CITY OF ALBUQUERQUE

December 29, 2022

Re: Fabrication Facility
10200 Bell Ave. SE
30-Day Temporary Certificate of Occupancy
Transportation Development Final Inspection
Architect's Stamp dated 01-15-21 (L20-D075)
Certification dated 12-29-22

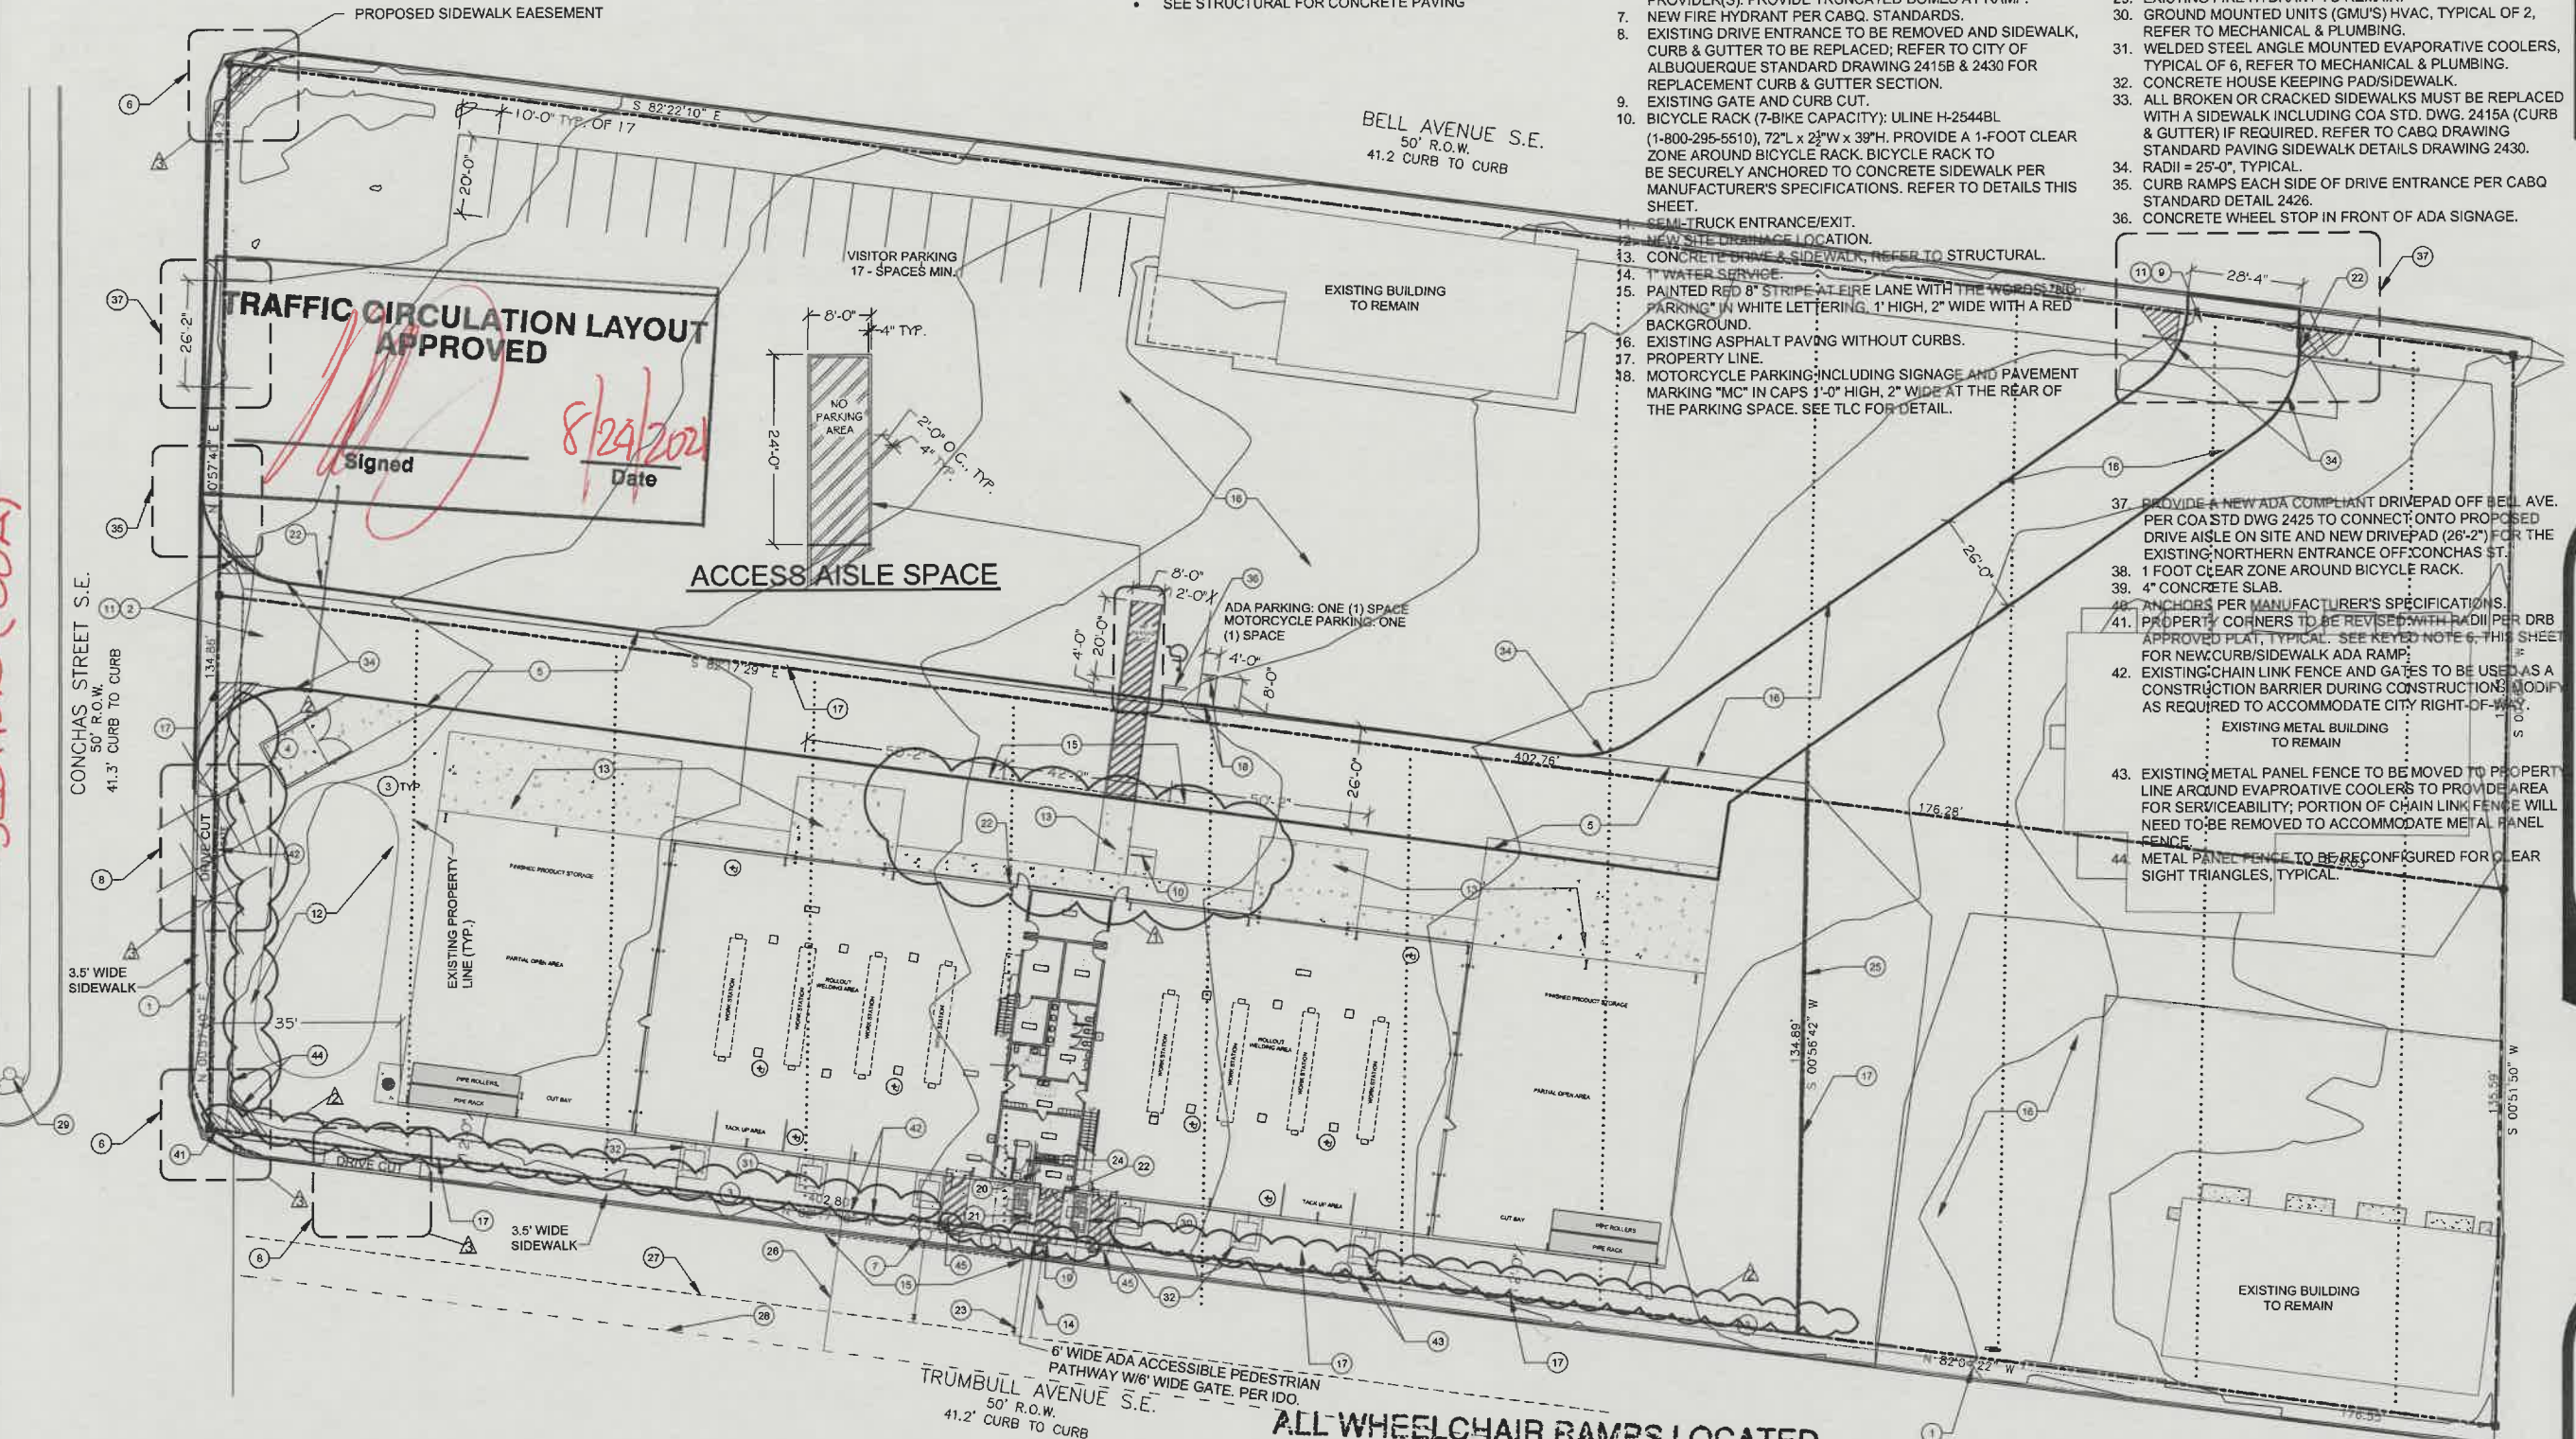
- Provide a copy of the sidewalk easement.
- The ADA accessible parking sign must have the required language per 66-7-352.4C NMSA 1978 **"Violators Are Subject to a Fine and/or Towing."** Please call out detail and location of signs.
- Provide a sidewalk taper (Pedestrian access rout) around the new drivepad off Conchas St.
- Truncated Domes need to be installed at the corner ramp of Conchas st. and Trumbull Ave.
- The running slope for the ADA ramp at the corner of Conchas and Trumbull is 10%. Per City standard the max. slope should not exceed 8.3%. please fix this issue.
- Please remove all the construction equipment and debris from the site.
